**WEST SUSSEX COUNTY COUNCIL
STRATEGIC PLANNING CONSULTATION**

FROM: Jamie Brown
TO: Arun District Council
FAO: Richard Temple

SUBJECT: FP/268/17- Detached 9No. bedroom annexe for Beachcroft Hotel with 9No. car parking spaces.

Boat Pound between Greenock Villa and The Gunpoint, Clyde Road, Felpham, PO22 7AH
RECOMMENDATION:

Figure 7 Lower Ground Floor Parking Plan

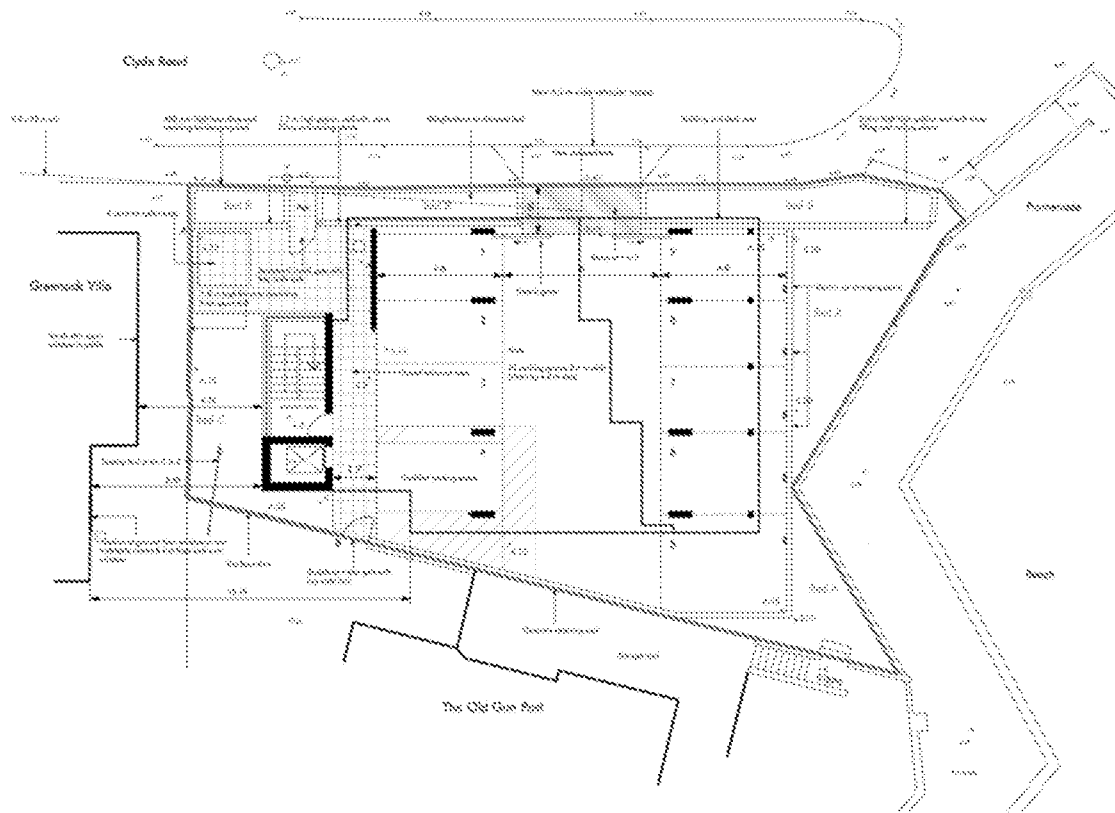
The proposals will have 9 car parking spaces located in an undercroft car park. The allocation is considered sufficient for the purposes of the application.

No part of the development shall be first occupied until the car parking has been constructed in accordance with the approved site plan. These spaces shall thereafter be retained at all times for their designated purpose.

DB32 Private Car	4.223m
Overall Length	1.715m
Overall Width	1.362m
Overall Body Height	0.233m
Min Body Ground Clearance	1.629m
Max Track Width	4.005m
Lock-to-lock time	5.760m
Curb to curb Turning Radius

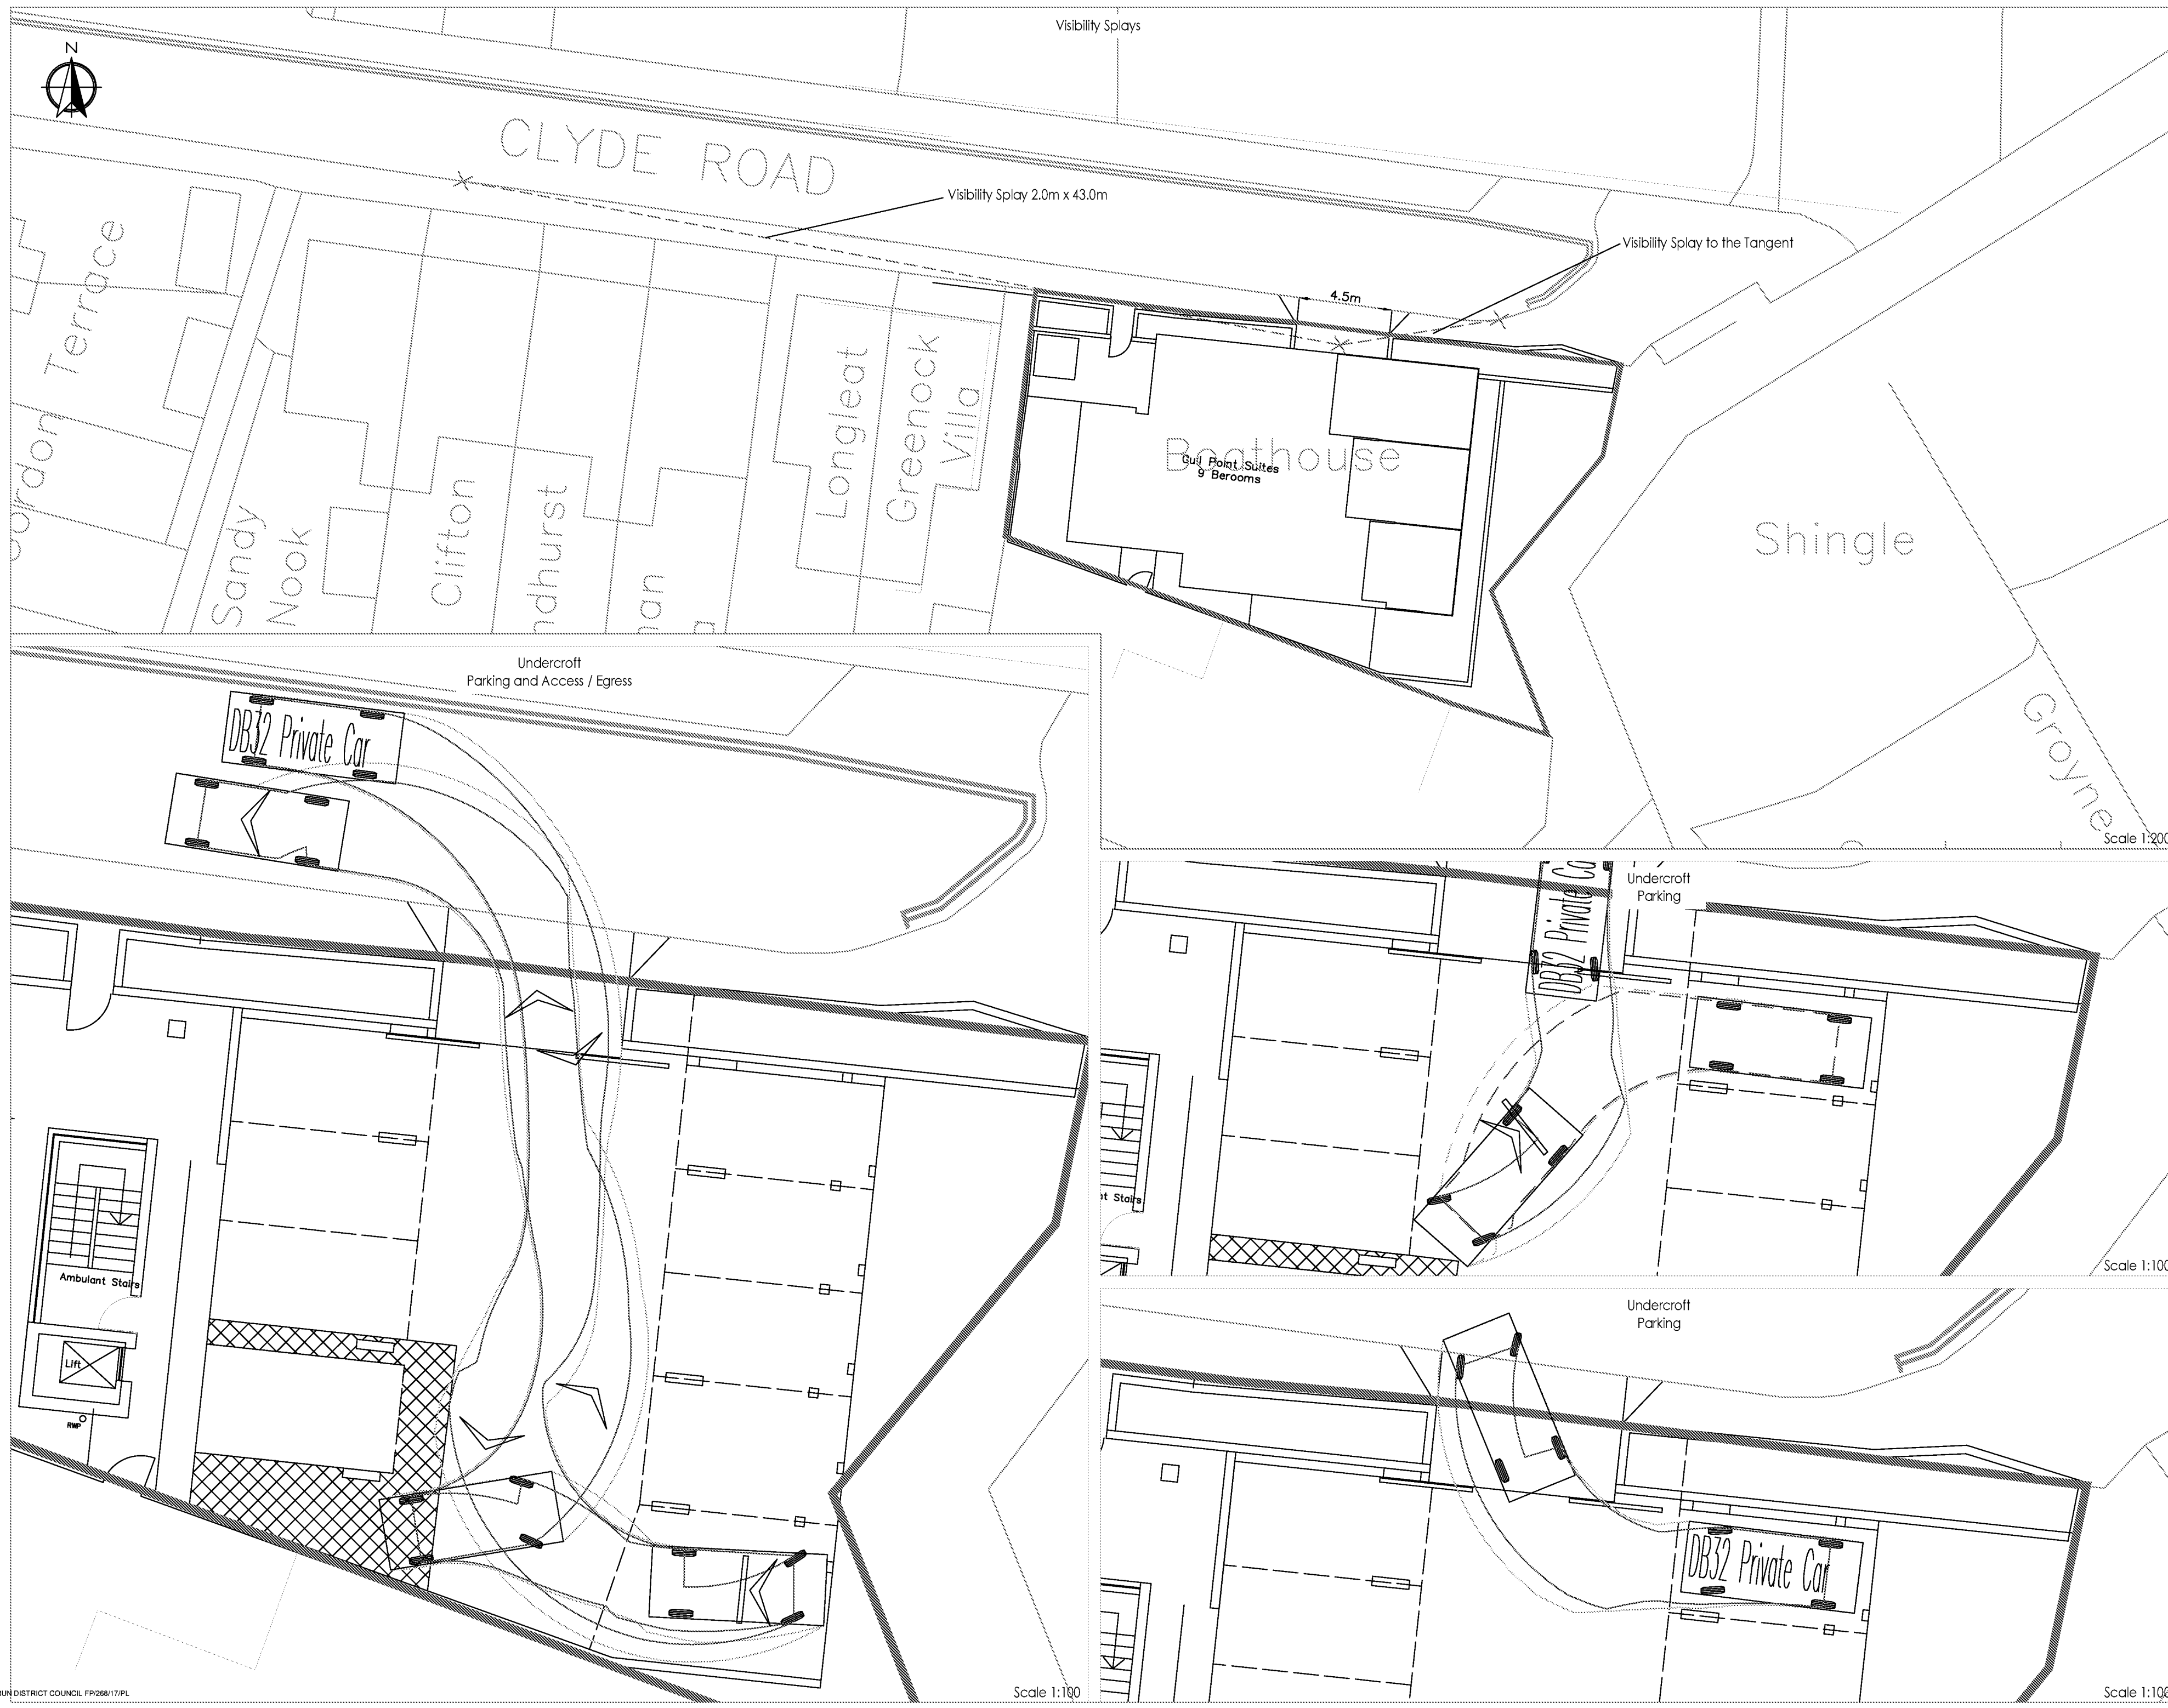
Swept path diagrams have been provided demonstrating that vehicles can turn into the access, whilst the LHA acknowledge that this could be tight consideration is given to the low number of vehicular movements and the lightly trafficked nature of the road.
